**North West Rail Link
Environmental Impact Statement 2
Application Number SSI-5414**

Re: North West Rail Link – EIS 2 - Application Number SSI-5414

Figure 6.23 Northwest Station - Indicative layout

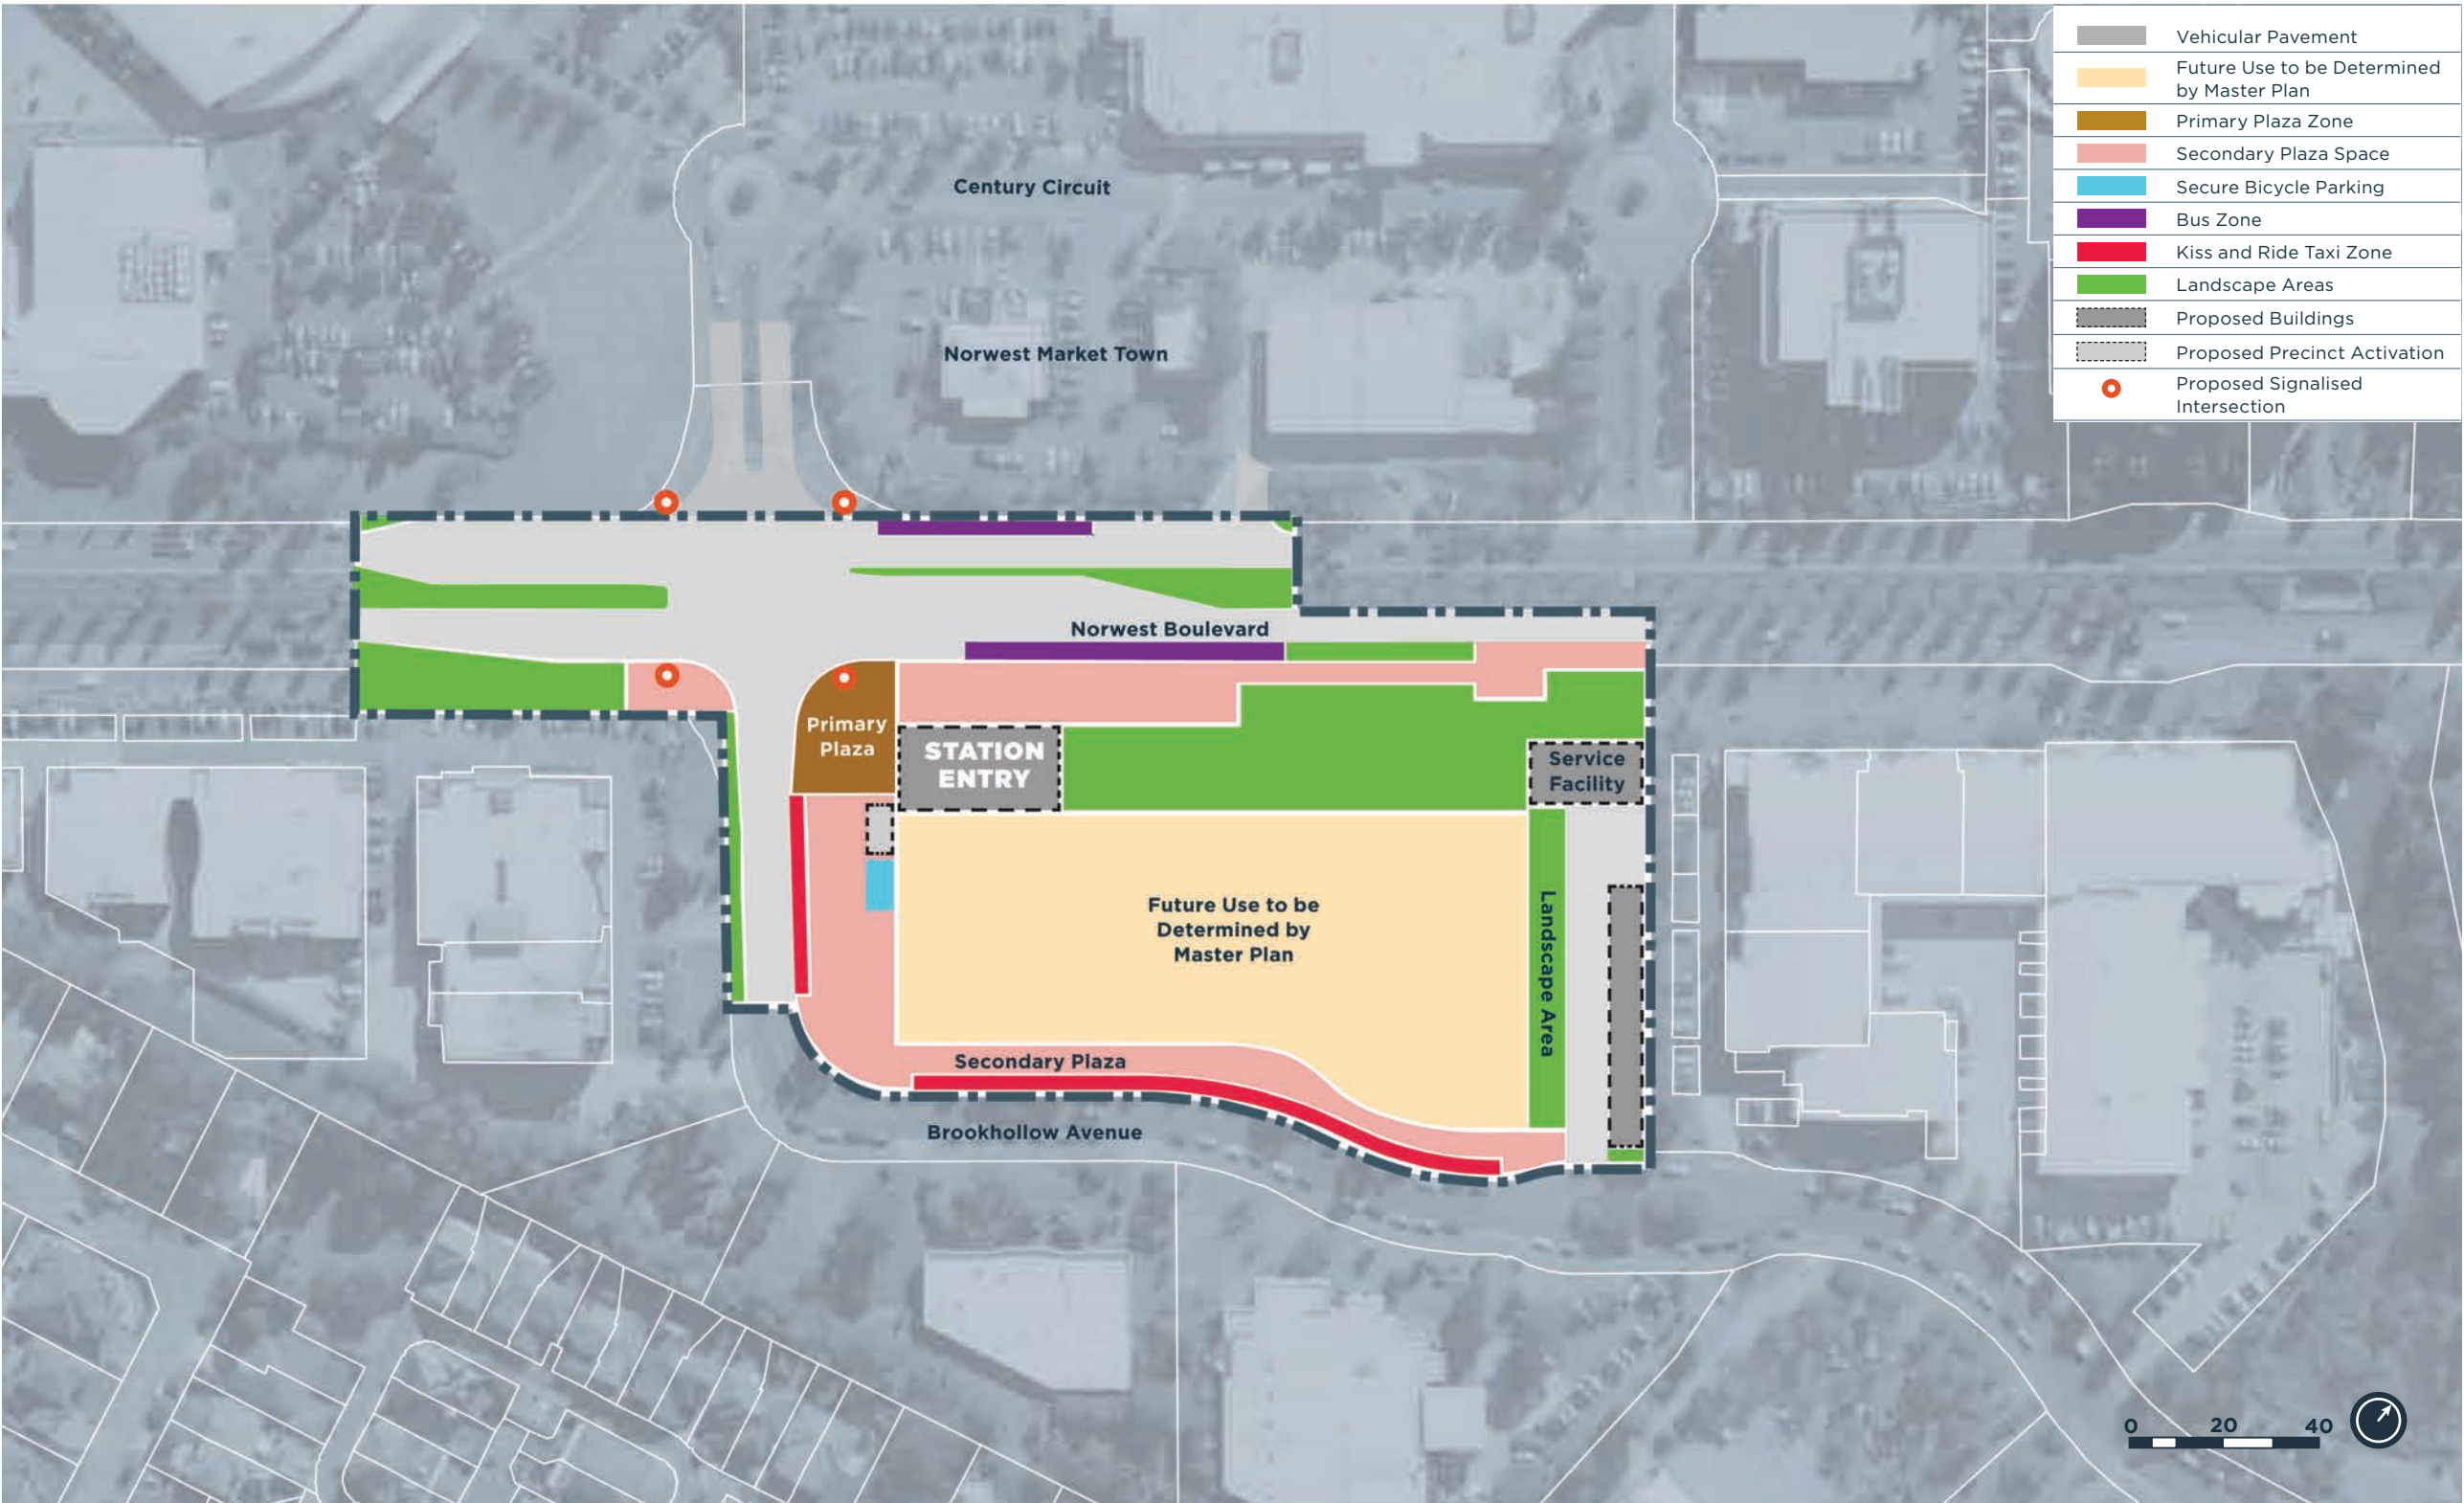
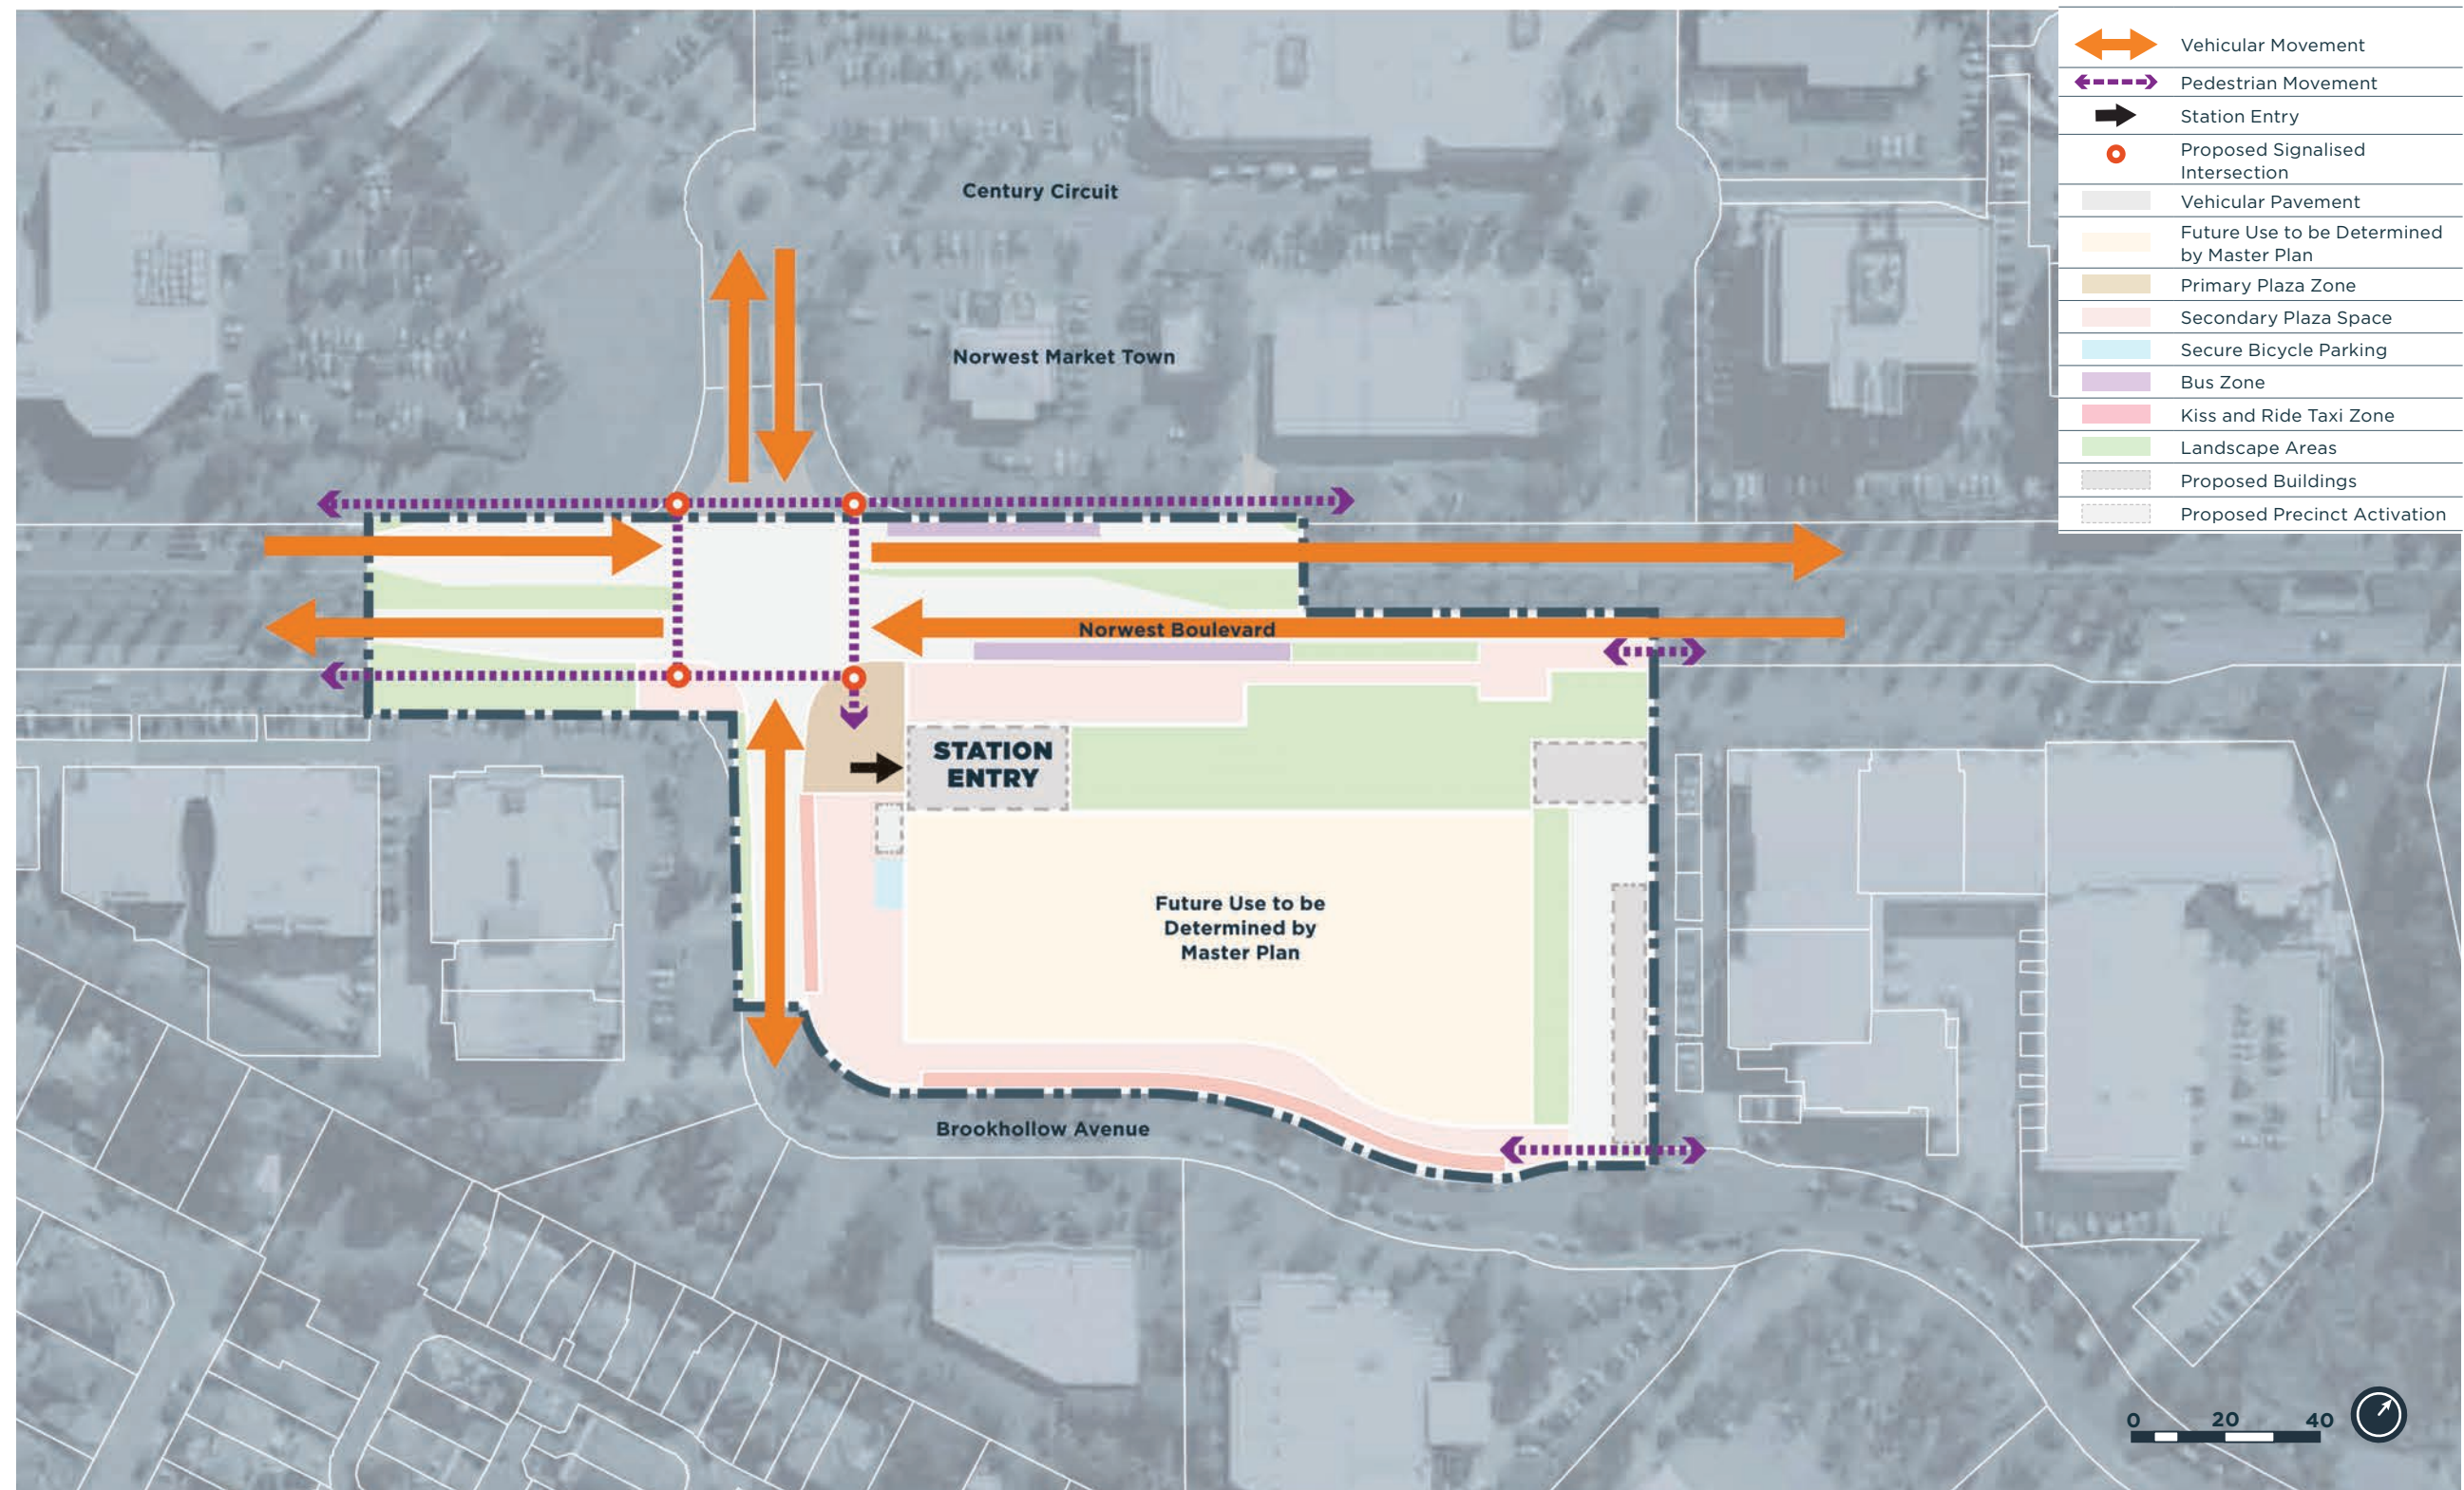
While we support the signalisation of the intersection of Norwest Boulevard / Brookhollow Ave / Century Circuit, we believe that there will be constant disruption to the flow of traffic if provision is not made for a pedestrian underpass or footbridge over Norwest Boulevard at the time the station opens.

Significant pedestrian traffic will be generated from the Market Town Shopping Centre and the [REDACTED] located across the road from the proposed Norwest Station. Consequently a pedestrian crossing at the lights will impact traffic flow constantly. We therefore believe measures beyond a signalled crossing are necessary.

In addition, the church's peak attendance is on weekends and the traffic lights need to be timed appropriately to take into account the large volumes of cars and buses that enter and exit the [REDACTED] site. We are happy to provide a detailed brief of our requirements as we approach the completion of the signalisation of the intersection.

[REDACTED] has, at its Norwest facility, car parking in excess of 1200 spaces. Its peak usage is predominantly on Saturday evenings after 6pm and all day Sundays. During weekdays, the majority of these car spaces are vacant. We would like the opportunity to discuss how a shared car park facility could be utilised for the benefit of all stakeholders. It is our belief that if a car park is not provided for use near the Norwest Station, the surrounding road network will become the default car park of choice.
